Reference No:	2024/62/90078/W
Site Address:	58, Southfield Road, Waterloo, Huddersfield, HD5 8RJ
Description:	Erection of 1800mm high close boarded boundary fence
Recommending Officer:	Lucy Taylor

DECISION – REFUSED

Officer Report.

EXISTING AND PROPOSED SITE
PLANS. NEW 1800MM HIGH FENCE

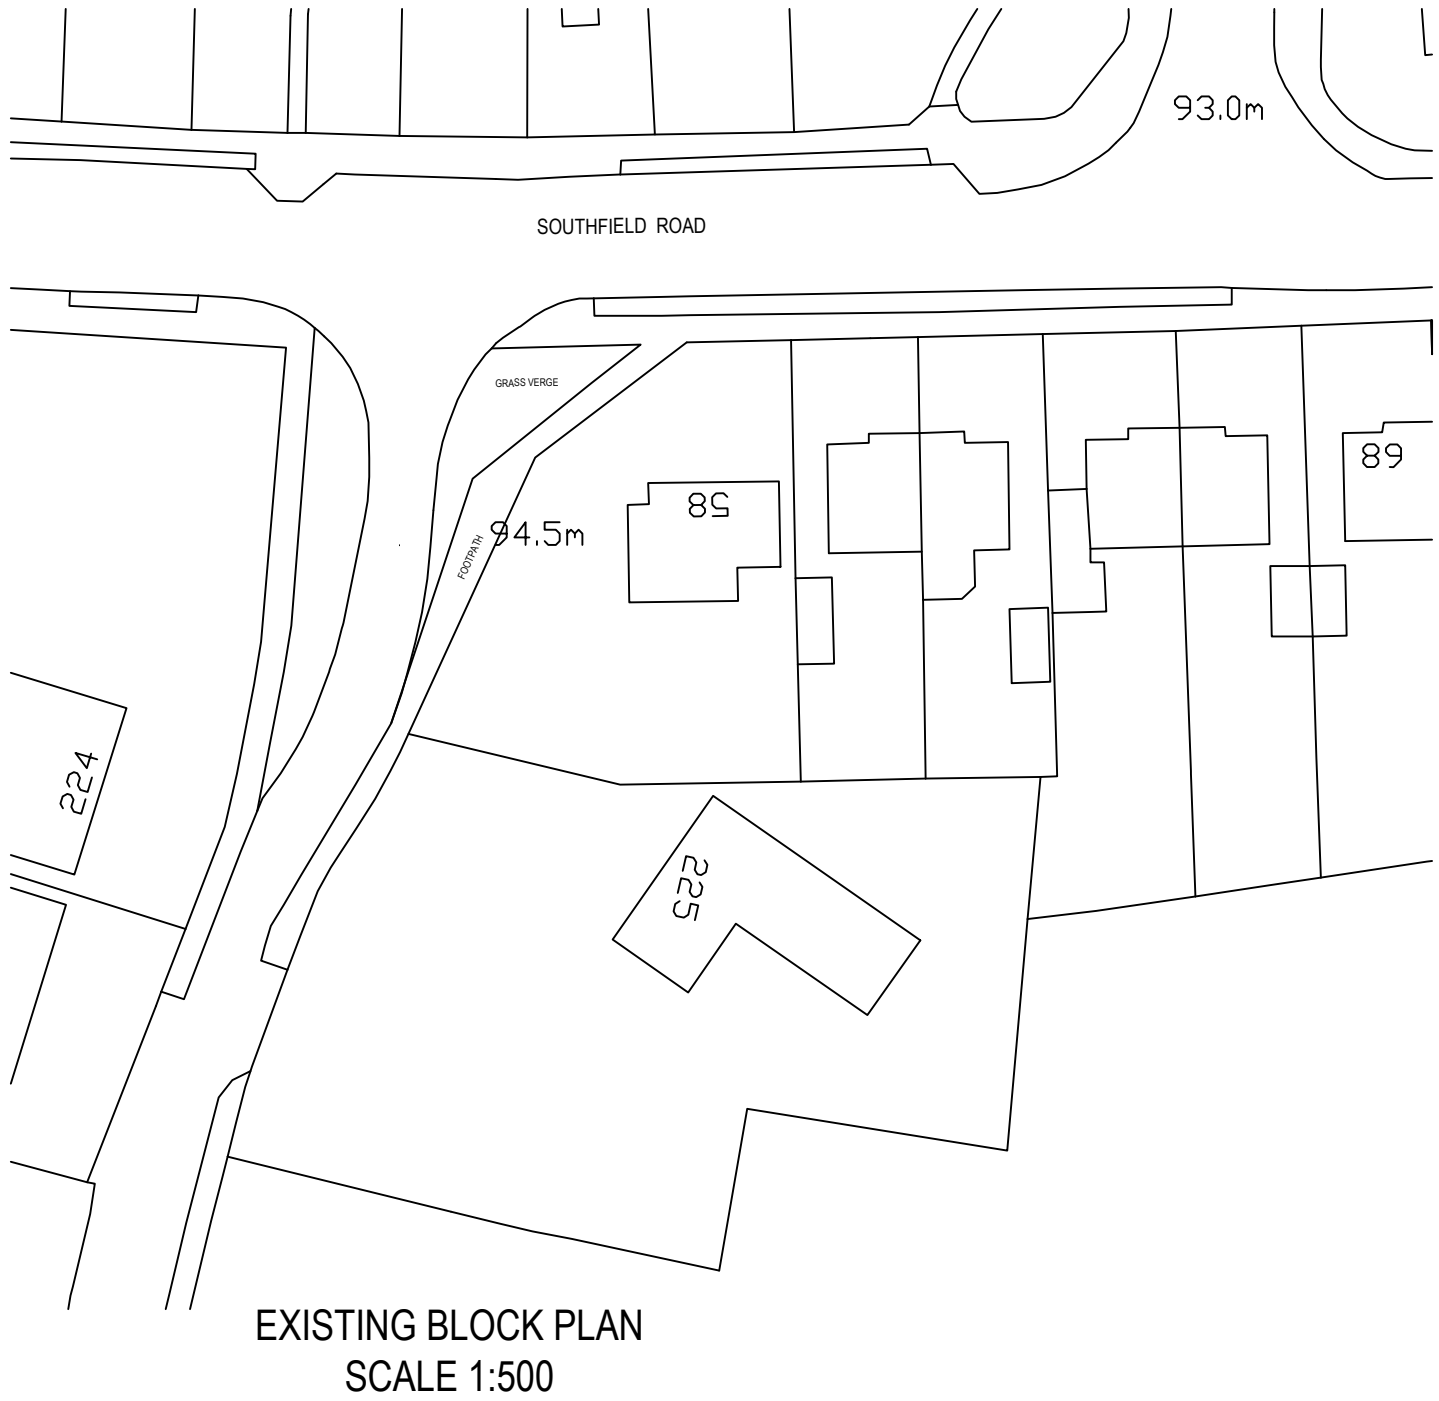
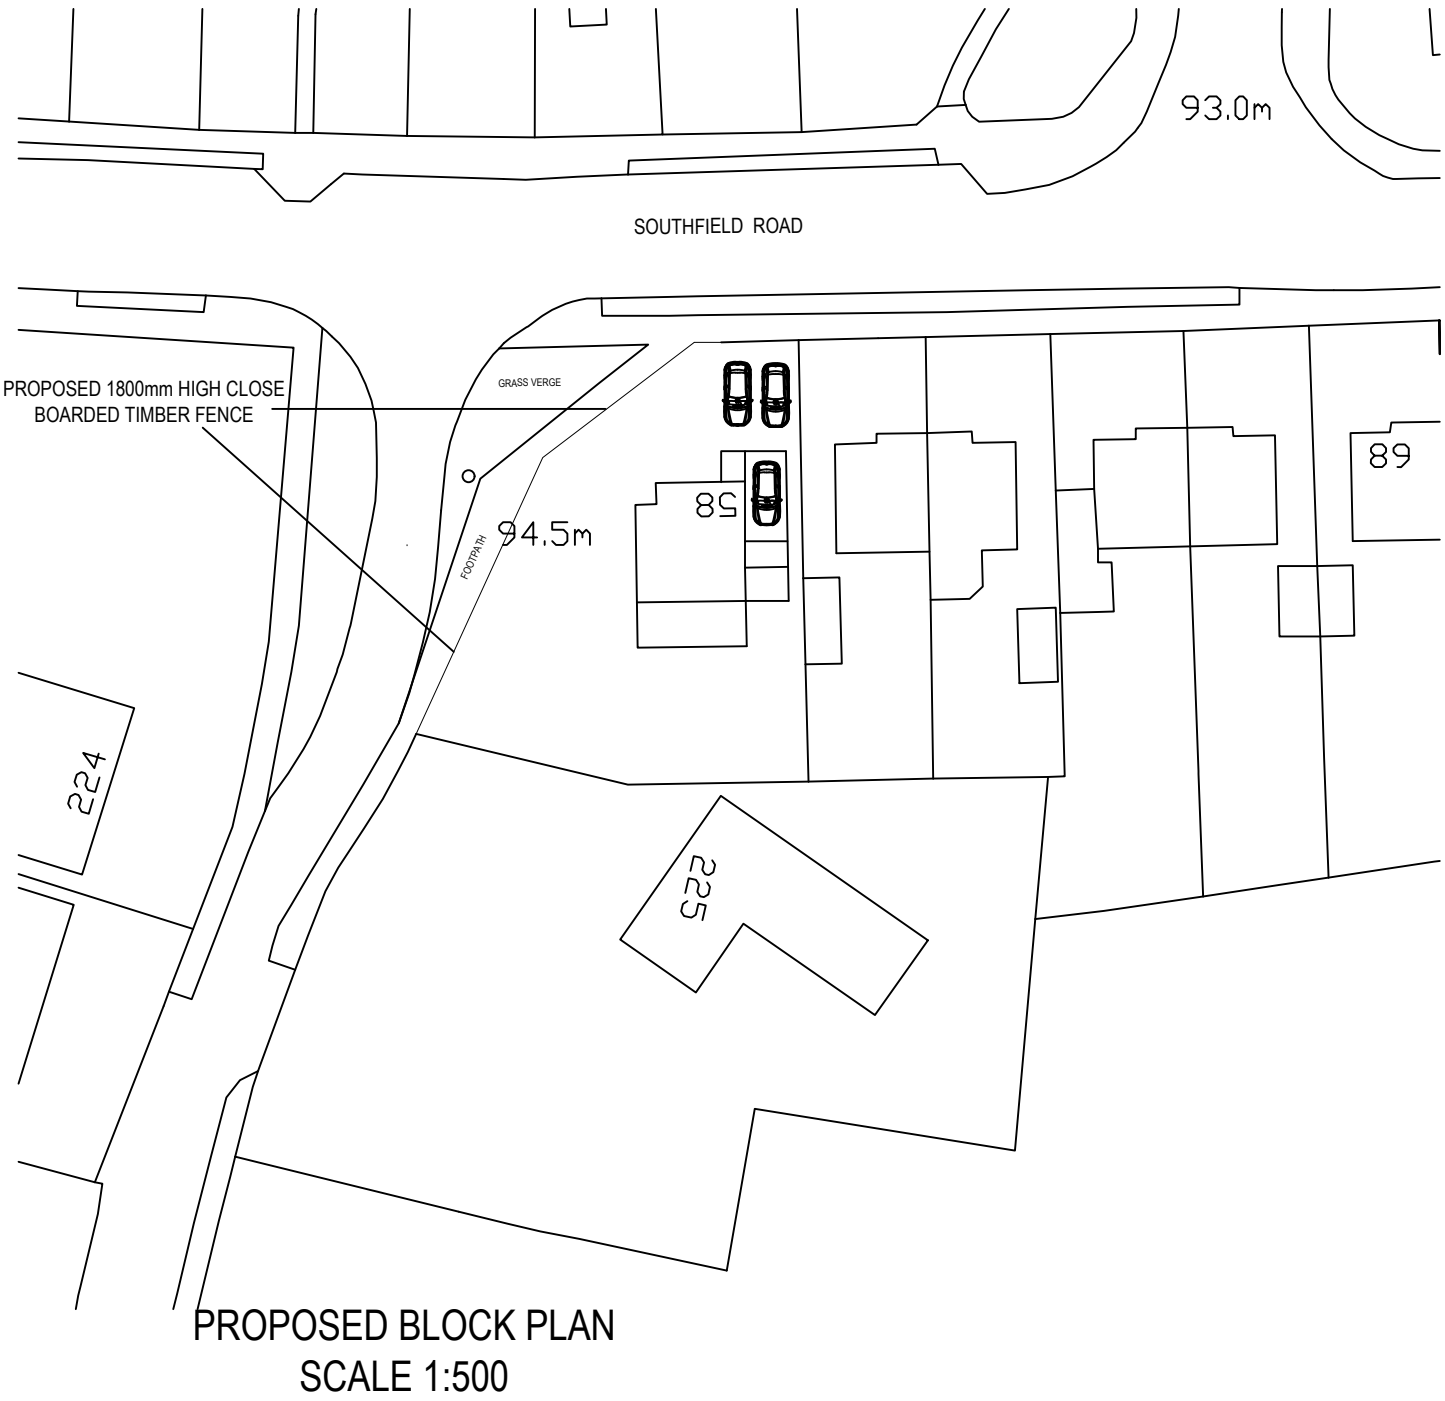
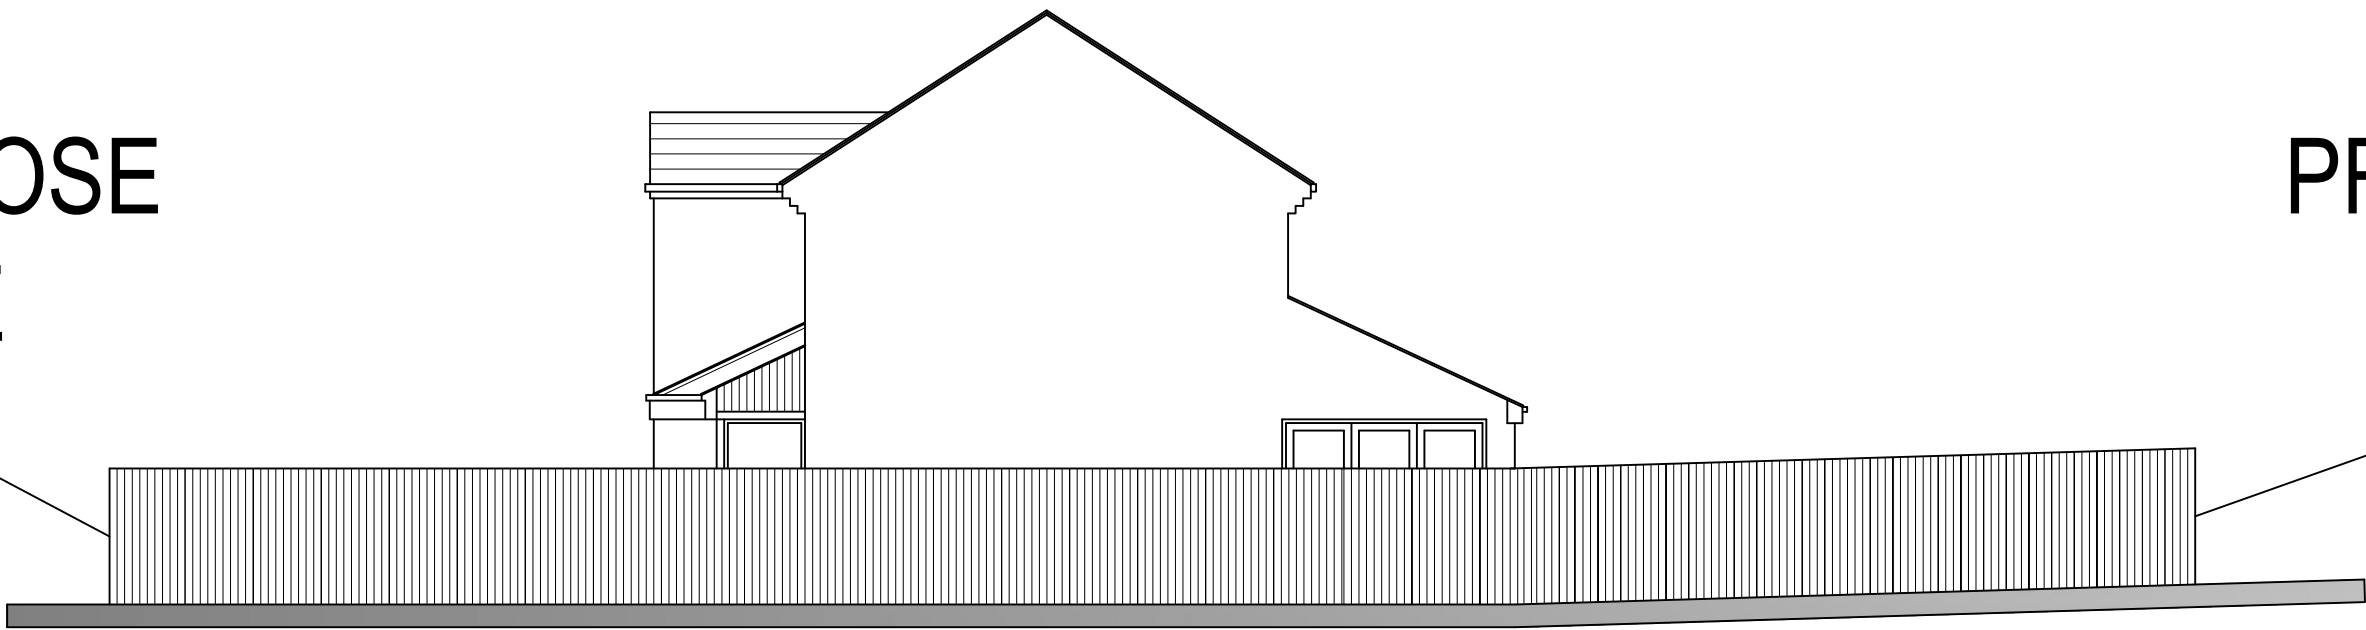
The development has seen the erection of a 1800mm high close boarded timber fence, coloured light brown, along the boundary adjacent to Fleminghouse Lane and Southfield Road. At the time of the officer site visit, the fence was in situ and can be seen on Google Maps Street view software.

Boundary treatments which front the highway in the immediate vicinity are characterised by low stone walls and low-level fencing. Prior to the erection of this boundary fence, No. 58 Southfield Road benefitted from a low stone wall

along the boundary adjacent to Fleminghouse Lane and Southfield Road, which appears to have been removed to facilitate the fence.

Due to the length, height and colour of the fence, it forms a stark, solid, formal barrier with a harsh appearance, which is visually incongruous and has an unduly imposing and oppressive presence on the site boundary, which is visible from a wide scope of public vantage points, including from some distance along the highway of Southfield Road and Fleminghouse Lane.

The part of the street where the fencing has been constructed is has open and spacious character whereby large boundary treatments / intrusions to the amenity spaces adjacent to the highway do not form a common feature. The scale of the development has seen an addition which significantly impacts upon the character of this part of the street leading to a level of enclosure which is unduly oppressive and stark within the street scene, particularly taking into account the materials of construction of the boundary treatment.

It is therefore considered that the fence, which is both prominent and at odds with the street scene, has a deleterious and highly intrusive effect on the character and appearance of the street scene. This is contrary to Key Design Principle 1 of the SPD in terms of the impact on the locality and the street scene and Policy LP24 (a) of the Kirklees Local Plan.

The fence is set back so that the recommended visibility splays of 2.4m x 43m at the adjacent junction of Fleminghouse Lane with Southfield Road have been maintained. As a result, the proposed fence does not affect the existing sight lines.

1. The fence, as constructed with a height of 1.8m, forms a stark, solid, formal barrier with an appearance which is visually incongruous with its surroundings, and which has an unduly imposing and oppressive presence on Southfield Road and Fleminghouse Lane. The fence, which is both prominent and at odds with the street scene, has a deleterious and intrusive effect on the character and appearance of the local area. The development is harmful to visual amenity and contrary
